**KIRKLEES METROPOLITAN COUNCIL
INVESTMENT & REGENERATION SERVICE**

**DELEGATED DECISION TO DETERMINE APPLICATIONS FOR
CONSENT, AGREEMENT OR APPROVAL REQUIRED BY CONDITION**

Reference No:	2023/44/92180/W
Site Address:	Land Off, Manchester Road, Huddersfield, HD1 3JA
Description:	Discharge of condition 15 (Validation Report) of previous permission 2016/91026 for erection of 168 student studios with communal areas
Recommending Officer:	Ellie Thornhill

Officer report

Figure No. and Title	Figure II - Approximate Topsoil Sampling Plan
Project Name	Block A to C, Huddersfield Waterfront, Manchester Road, Huddersfield
Client	Hexa Consulting Limited
Service	Topsoil Validation Sampling
Date of Issue	October 2023
Project number	EGE-23-09-18-01

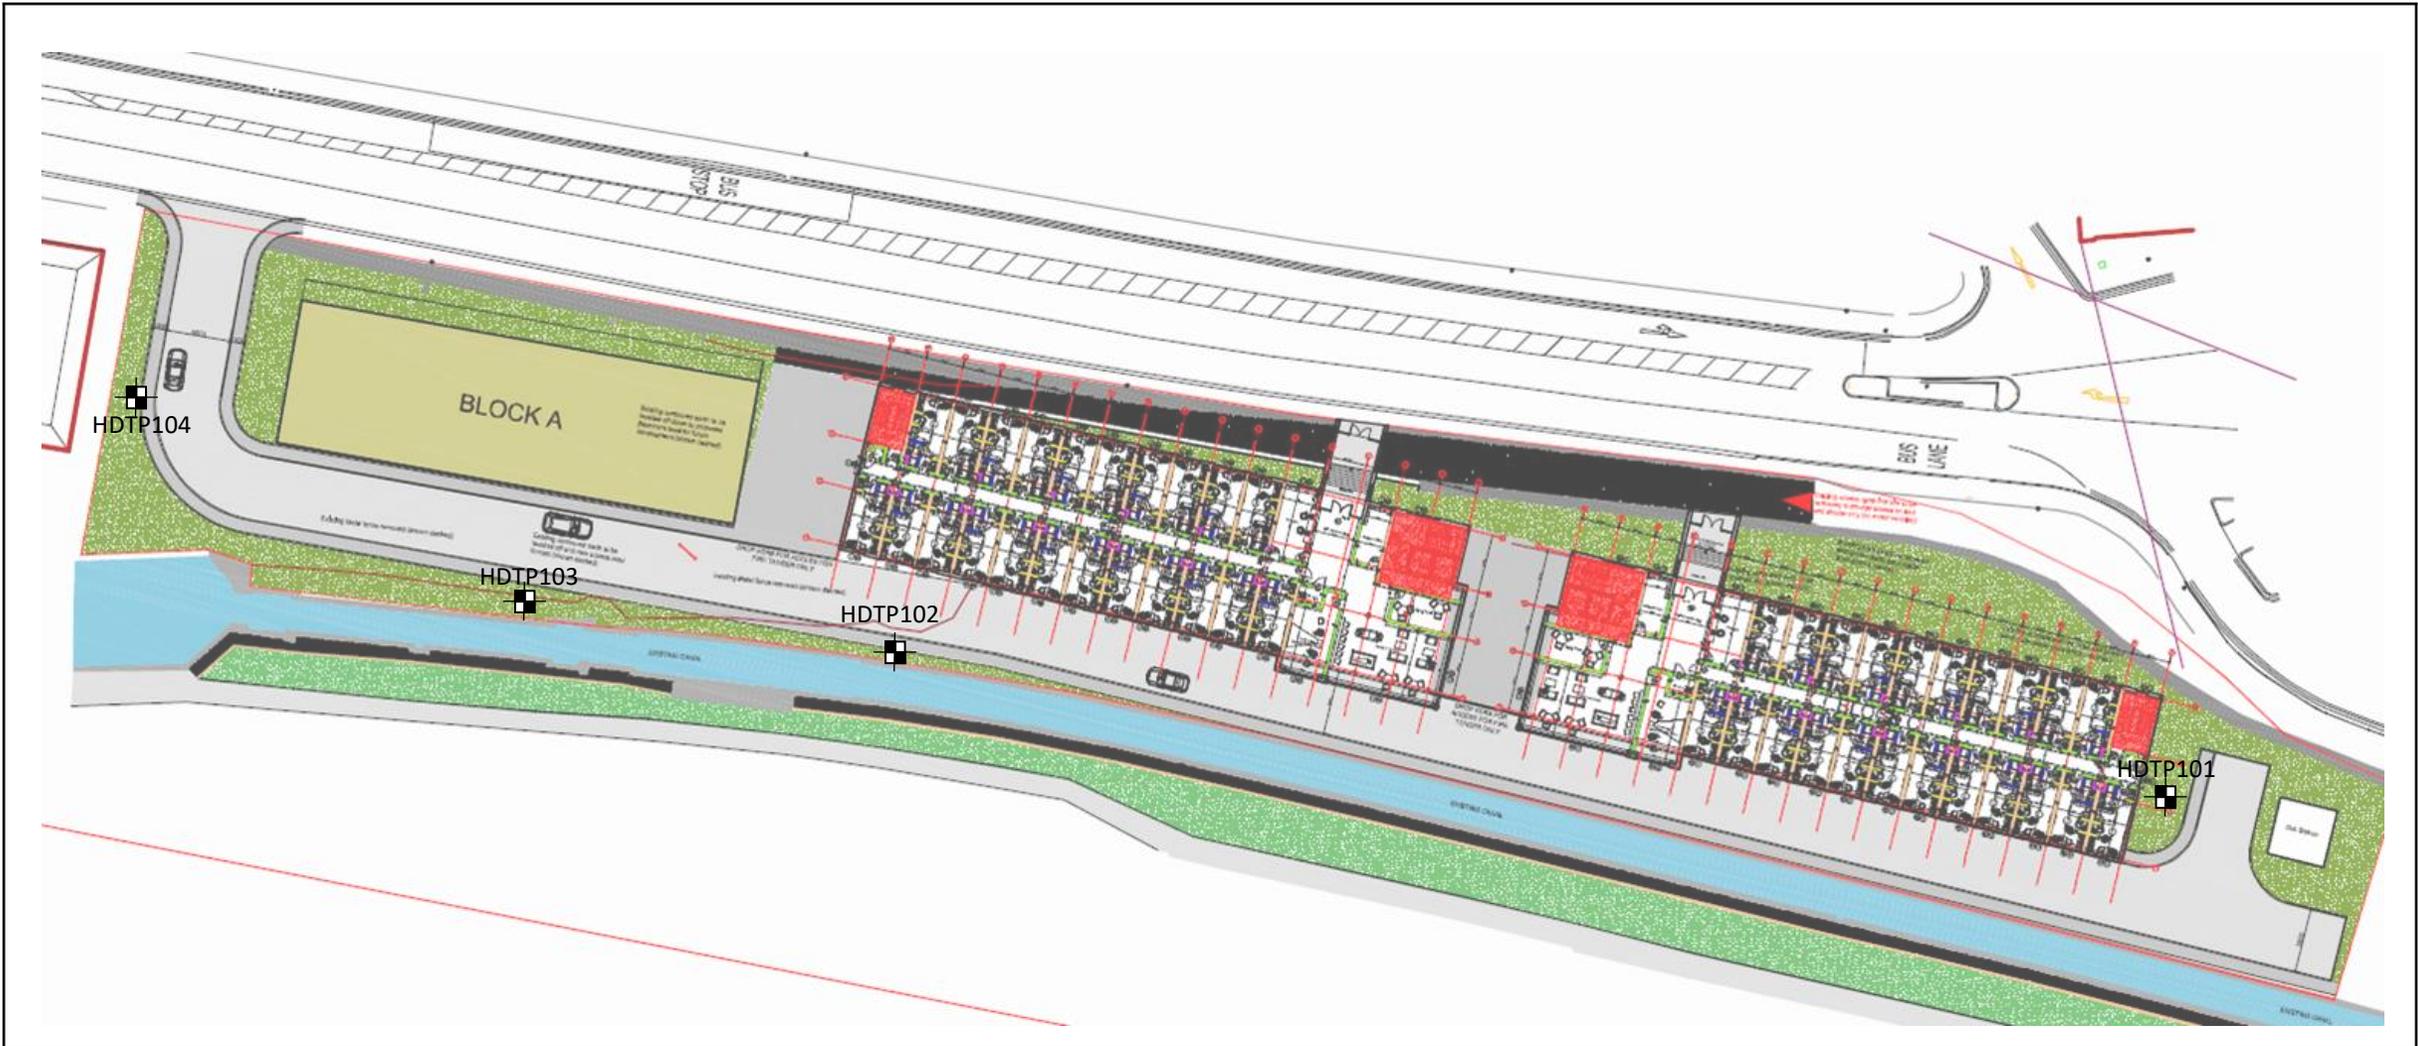
- Only 1 trial pit has been done in for Area A. It is unclear how this can demonstrate the absence of contamination, to a high degree of confidence.
- Appendix 2 is supposed to contain the delivery notes of imported material, but this has not been provided. Moreover, no samples have been provided to confirm the suitability of any imported material. This does not appear to be in accordance with best practice guidance.
- The material identified in all four trial pits is generally gravelly sandy clay soils (made ground) which appears to be the same as the generally ground conditions proven in the Phase 2 investigation.
- The depth of topsoil does not appear to be in accordance with the agreed strategy.
